Application Reference: 2026/91785

Site: Land off Reinwood Road, Reinwood, Huddersfield, HD3 4EQ

Proposal: Outline application for erection of up to 5 dwellings with all matters reserved expect layout and access

Sport England Reference: PA/26/Y/KK/74538

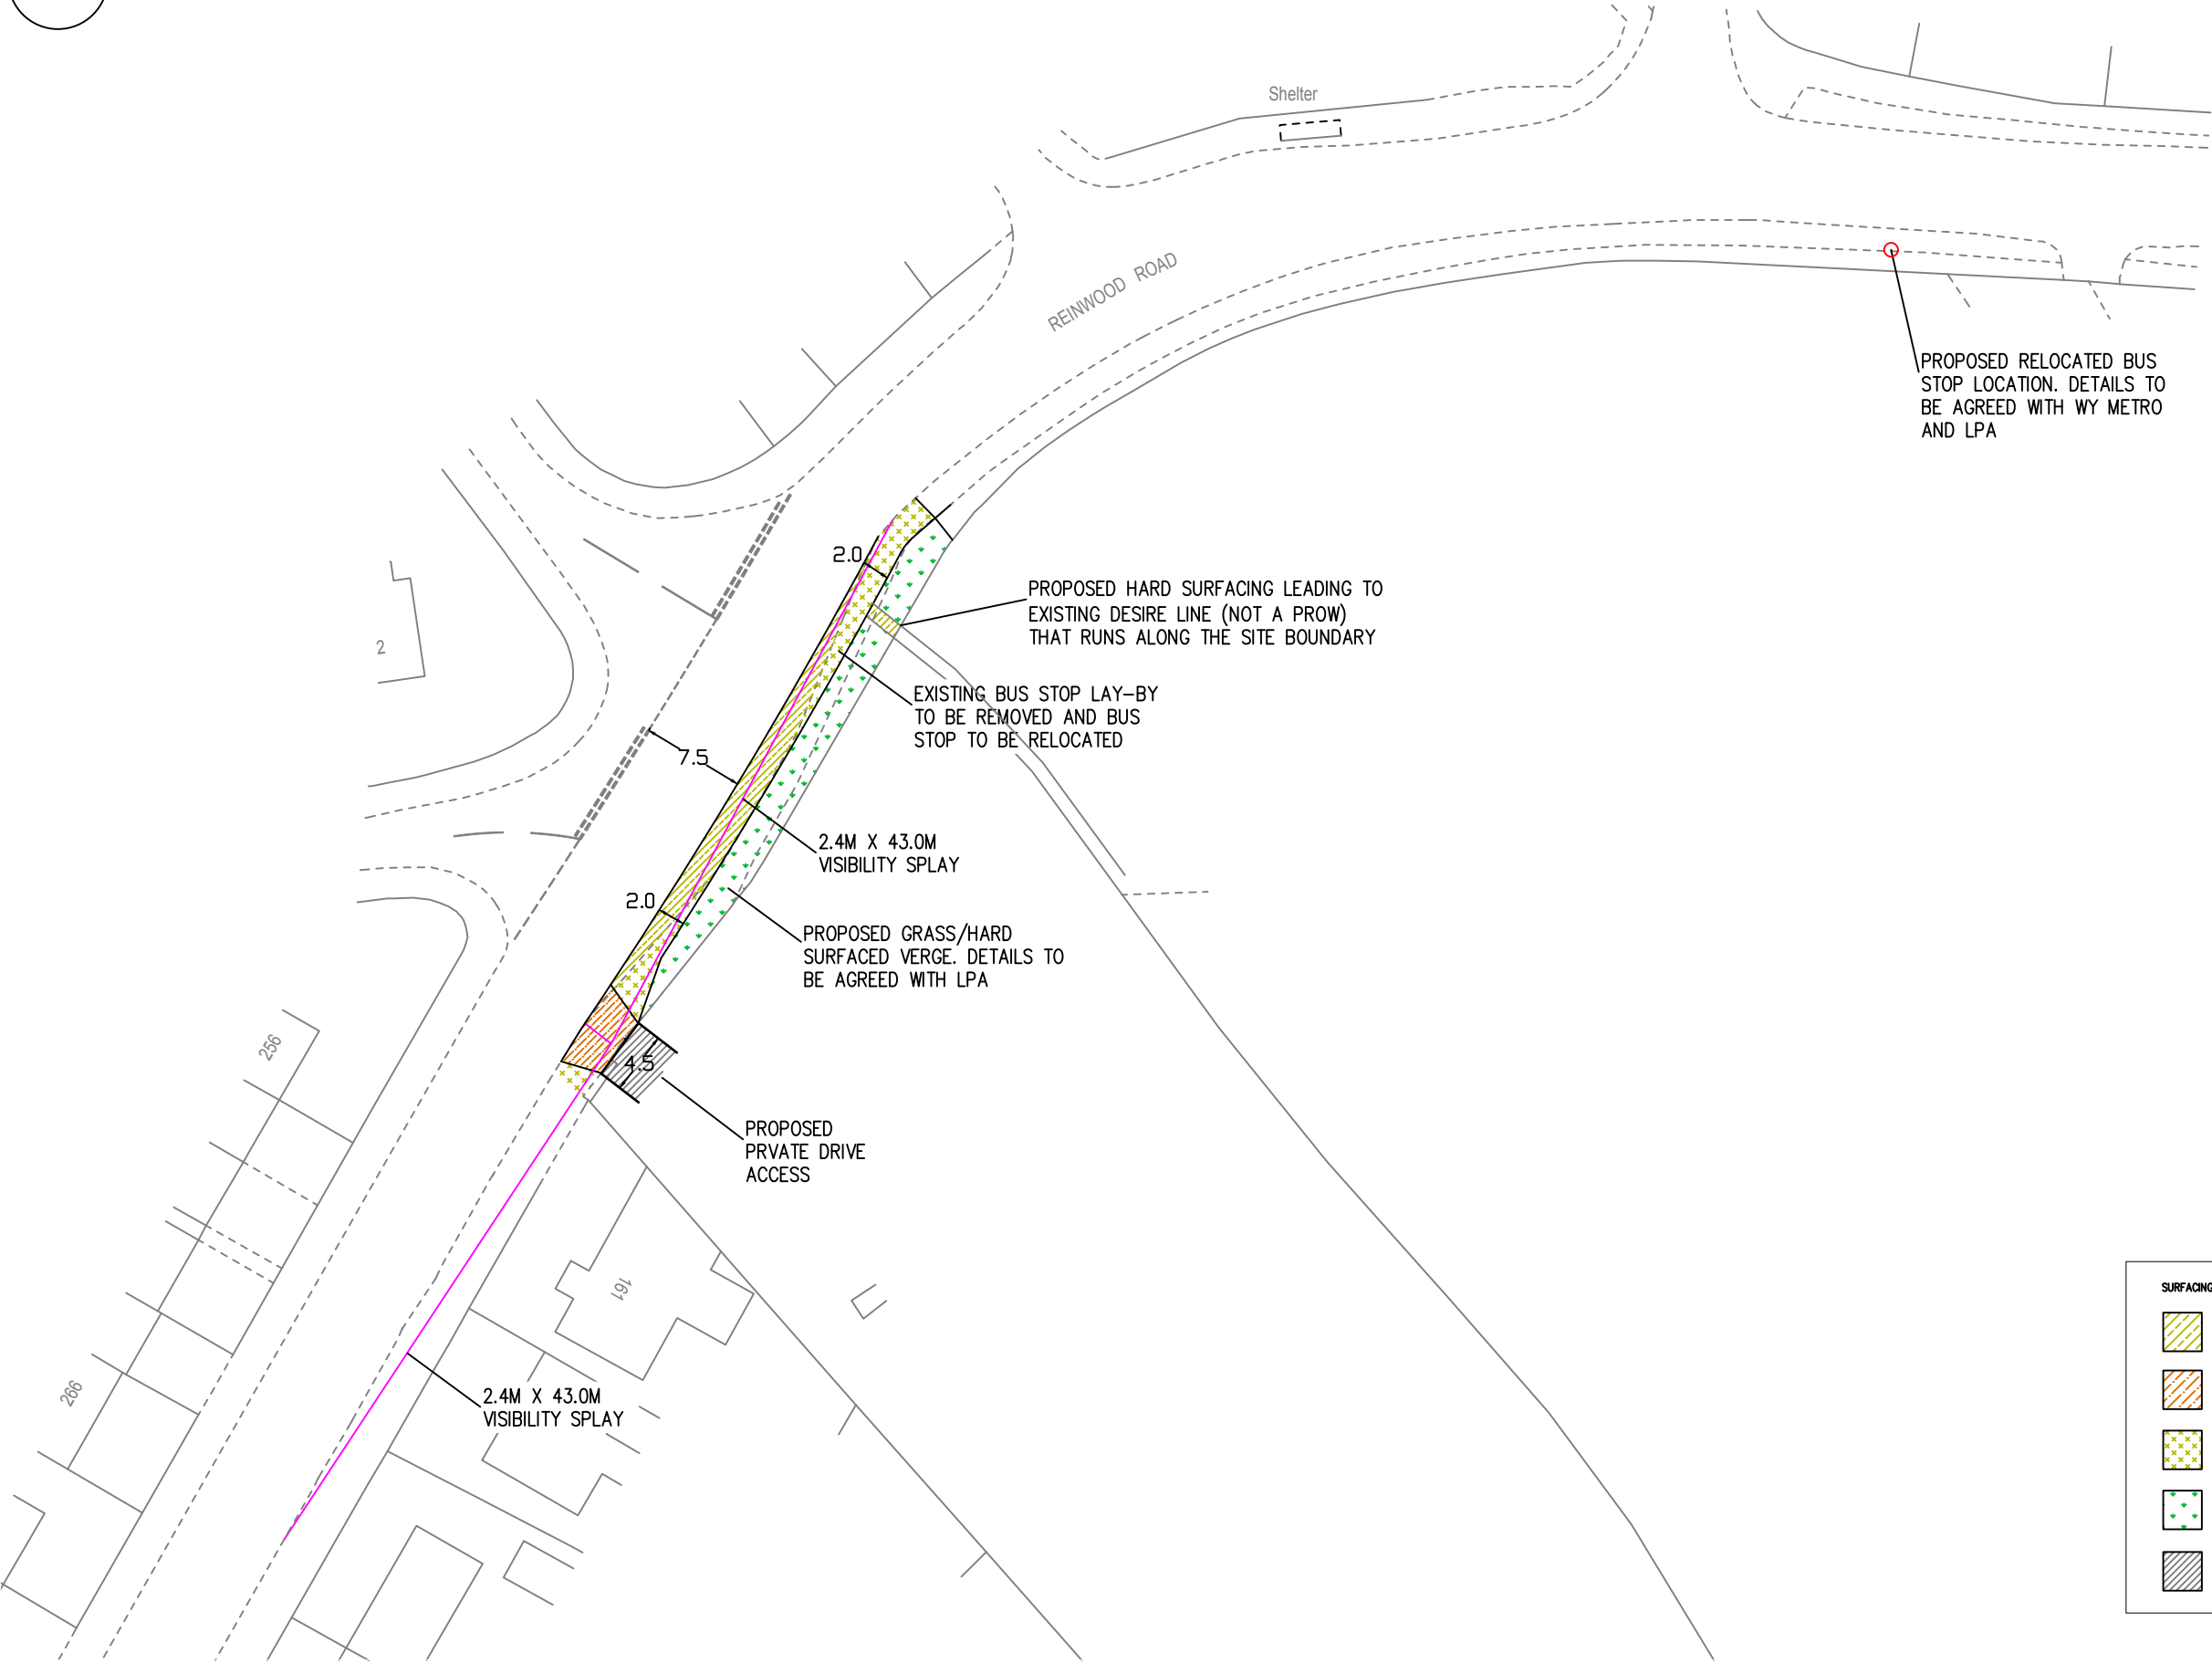
The schematic layout plan shows that the proposed residential development is on an area of land that appears to be pasture or grazing land. Google aerial images, including historic aerial images, show that this area of land is separated from the playing field to the east by a path and fence and has been clearly managed differently to the playing field which has been mown and delineated with a pitch over a number of years. Therefore, there is no indication that the area of land proposed for the housing has historically formed part of the wider playing field.

Provided that the proposed residential development does not have any encroachment onto the playing field to the east, the proposal would not result in the loss of any playing field.

The Football Foundation has raised no concerns regarding any prejudicial impact on the adjacent playing field. Nevertheless, Sport England recommends that the Local Planning Authority, in consultation with Environmental Health, satisfies itself that any potential noise and ball strike impacts arising from the adjacent playing field have been appropriately considered. This would be consistent with the 'agent of change' principle set out in paragraph 200 of the NPPF, which seeks to ensure that existing sports facilities are not subject to unreasonable restrictions as a result of new development.
